Arun District Council
Arun Civic Centre
Maltravers Road
Littlehampton
West Sussex BN17 5LF
Planning & Building Control General Enquiries
Tel: (01903) 737756 Fax: (01903) 730442
Dx: 57406 Littlehampton
Minicom: 01903 732765
e-mail: planning@arun.gov.uk
website: www.arun.gov.uk/planning

Application No: FP/86/21/PL
Site Address: 7 Ambleside Close Felpham PO22 8NG
Description of works: Erection of 1 No. 3 bed dwelling (resubmission following FP/179/20/PL). This site is in CIL Zone 4 & is CIL Liable as new dwelling.

Thank you for your internet representation made on 20th May 2021 which has been recorded as an objection with the comments as follows:

Site Layout - Proposed | 1:200@A3

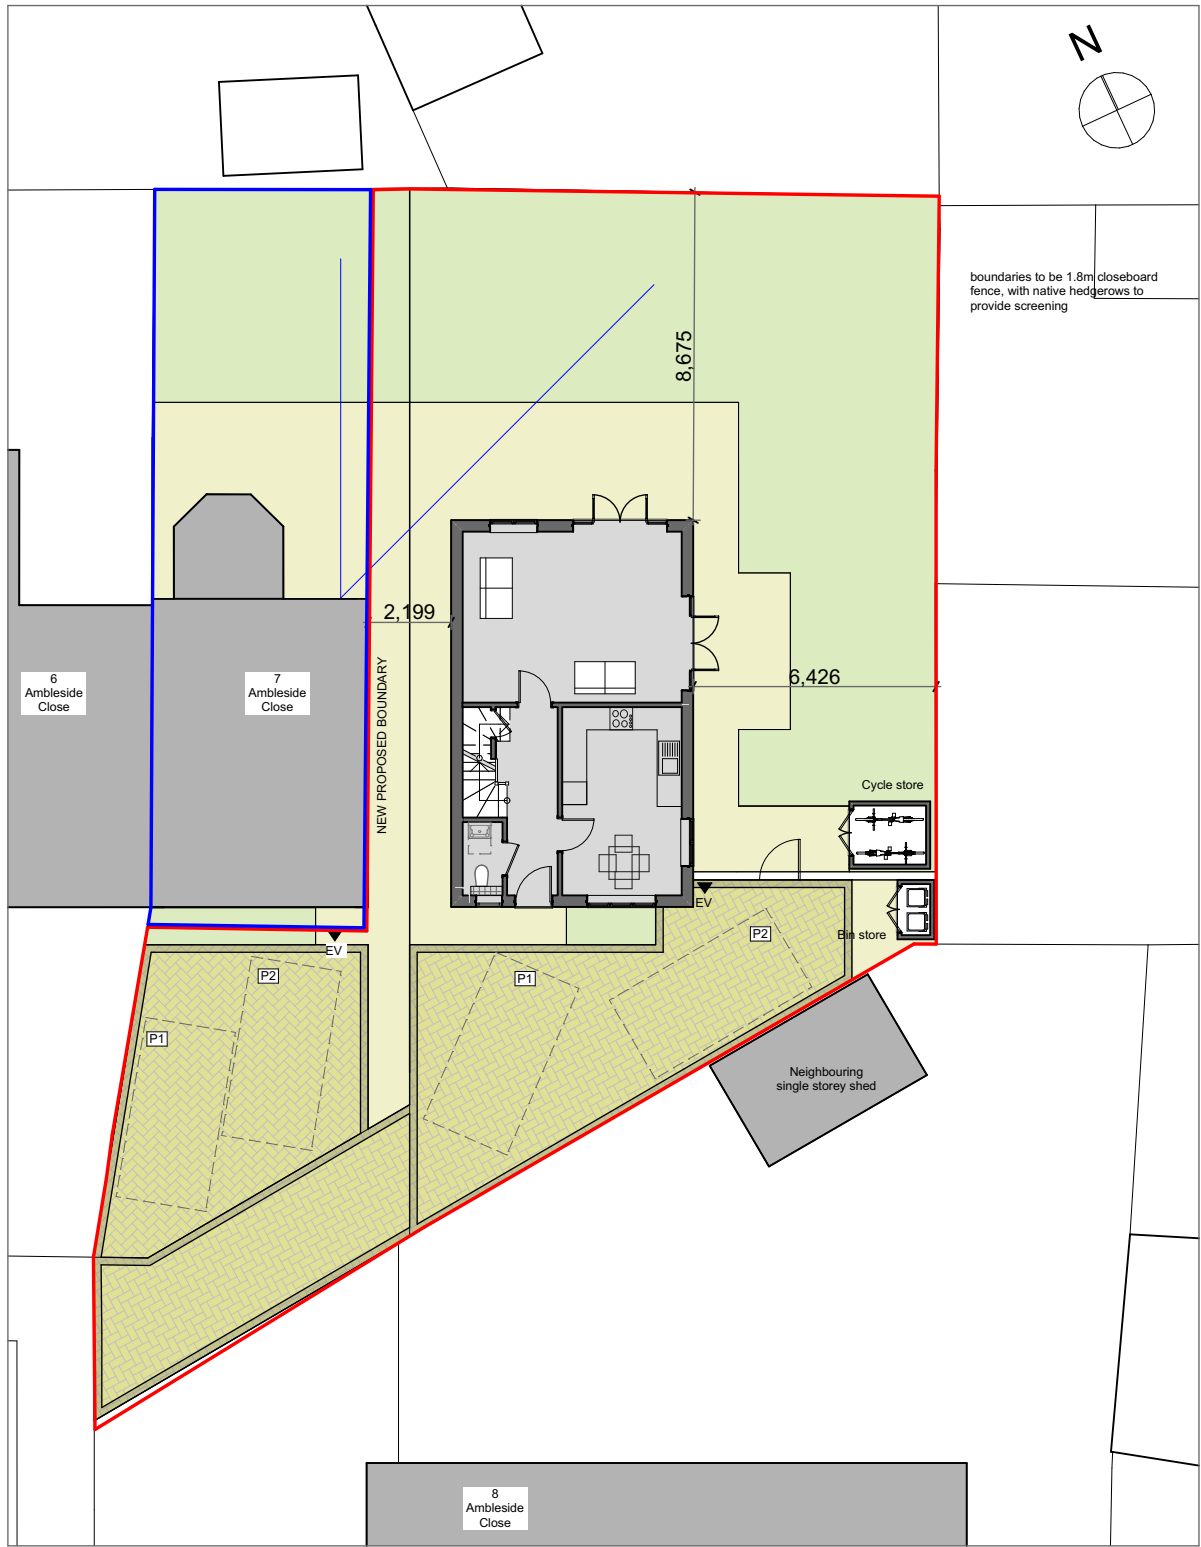
Objection there is no adequate turning circle for vehicles they would have to reverse onto the road and FPC have waste water concerns.
